Fosse Green Energy Development Consent Order – Deadline 4 Submissions

Planning Inspectorate Case Reference: EN010154

Indicative Layouts

Figure 3-2A SHEET 1 03

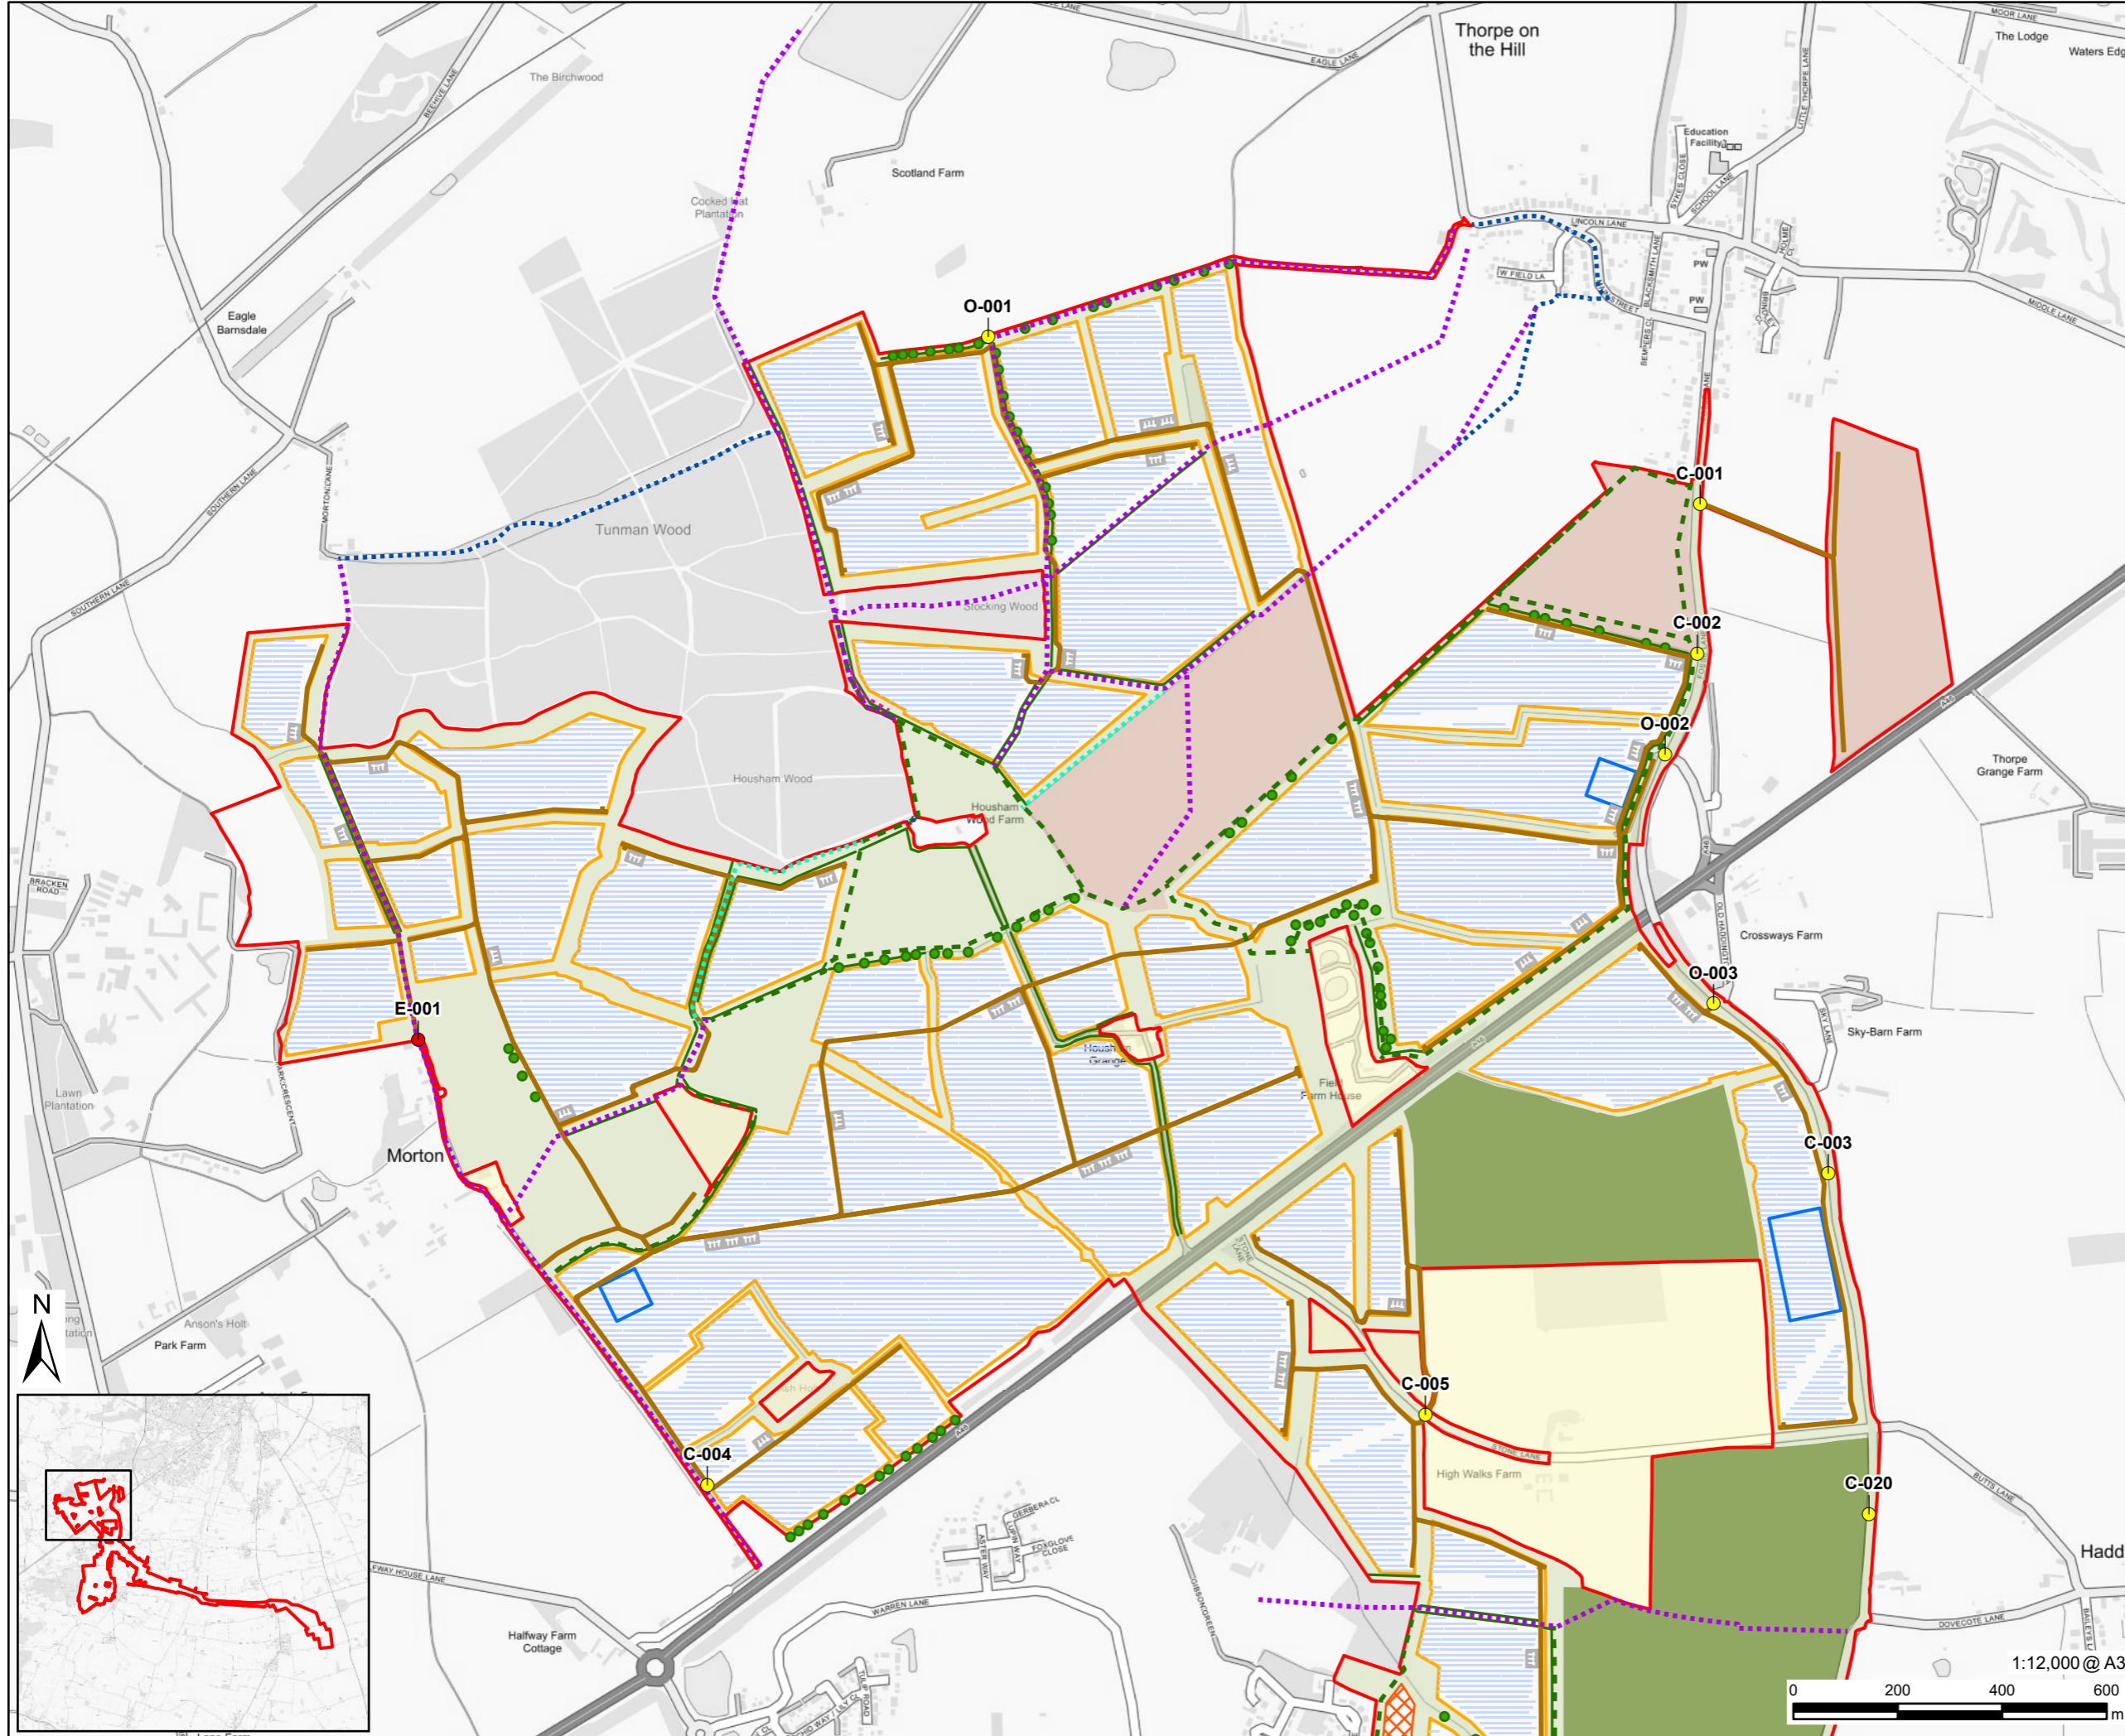
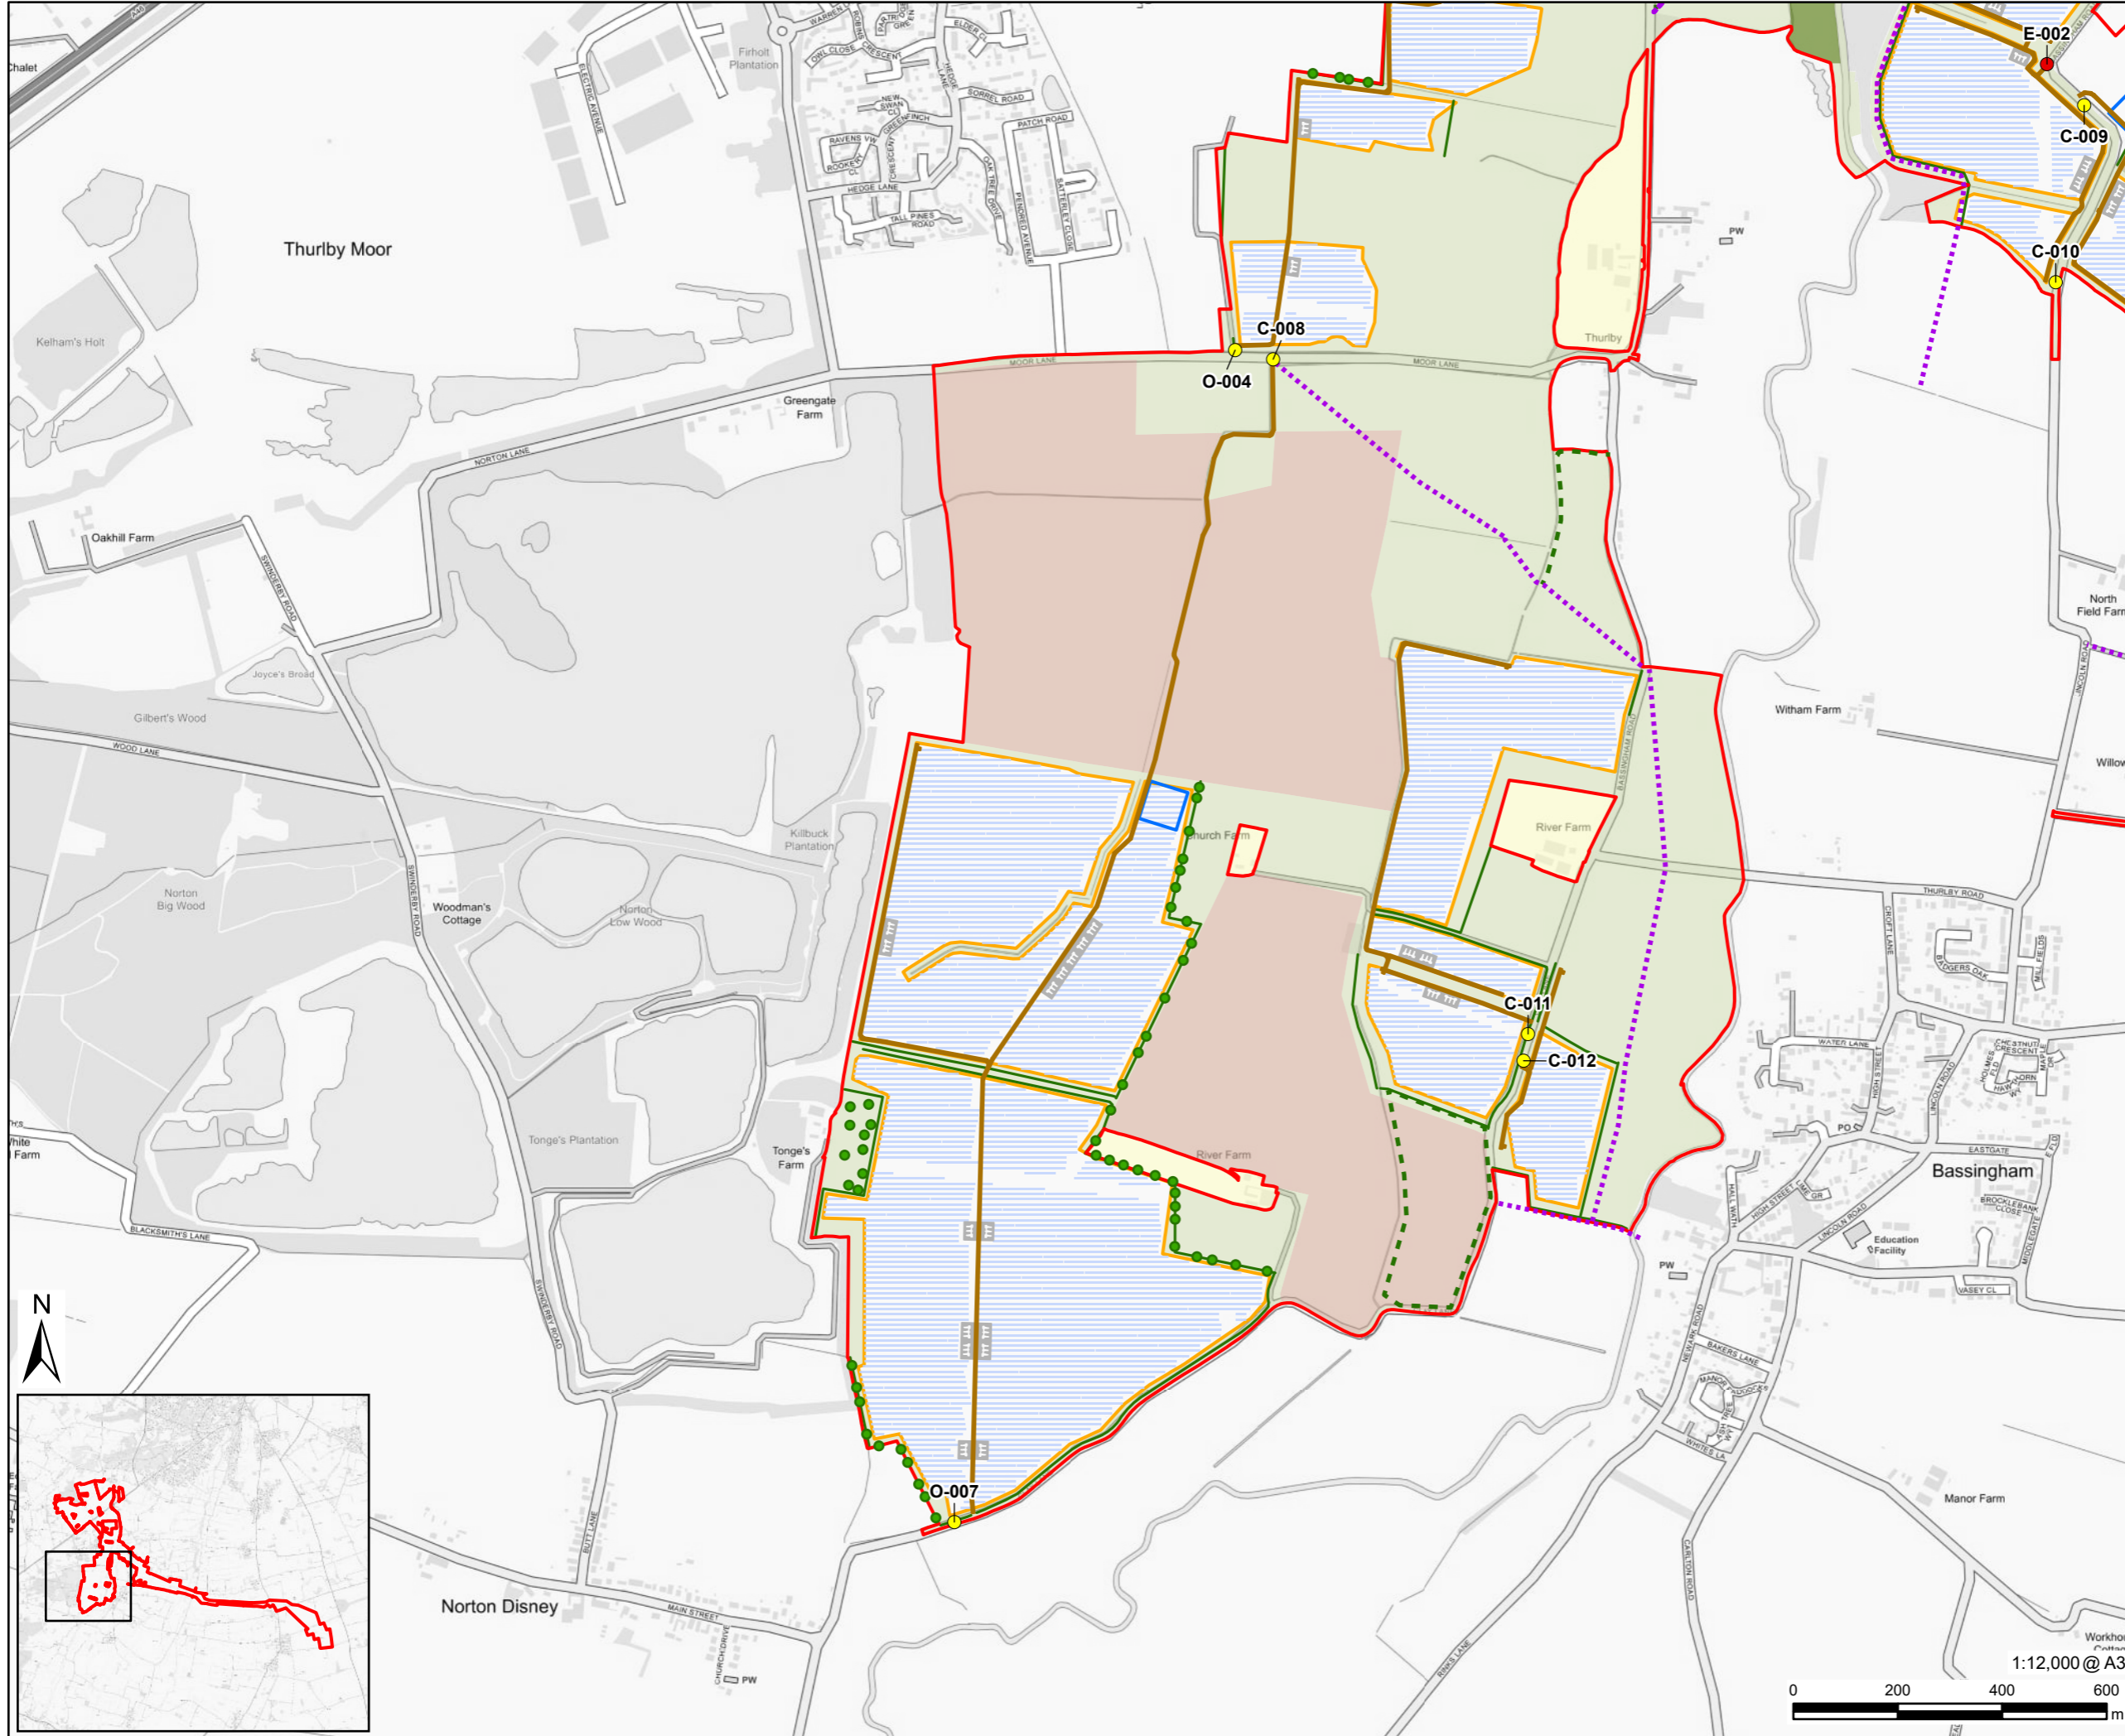
Figure 3-2A 'Indicative Fixed South Facing Layout' and 3-2B 'Indicative Single Axis Tracker Layout' have been updated and submitted as part of the Applicant's Deadline 4 submissions. The update includes additional permissive paths to facilitate the Stepping Out Routes referred to by North Kesteven District Council, enabling these to be walked during the operation of the Proposed Development. These permissive paths will be secured for the lifetime of the Proposed Development. The updates set out in Figure 3-2A and Figure 3-2B are as follows:

- a. A section of the Stepping Out Route to the south of Housham Wood will not be available, with alternative permissive paths provided that are located through grassland or arable fields rather than the existing farm track.
- b. A section of the Thorpe on the Hill Stepping Out Route will not be available, however there is alternative provision via a Public Right of Way.

The Applicant has also taken the opportunity to include within these Figures the changes previously presented in the Landscape Mitigation Plan (at Appendix A of the Framework Landscape and Ecological Management Plan) which formed part of the Change Request **[AS-123]** (the removal of solar in Field 46, the addition of new hedges near River Farm, and clipping of the Order Limits near Thurlby). The total length of the proposed permissive paths following this change is now 10.2km. The total length of the Stepping Out Routes within the Order Limits that are not currently PRow is 1.8km. The net difference is therefore 8.4km.
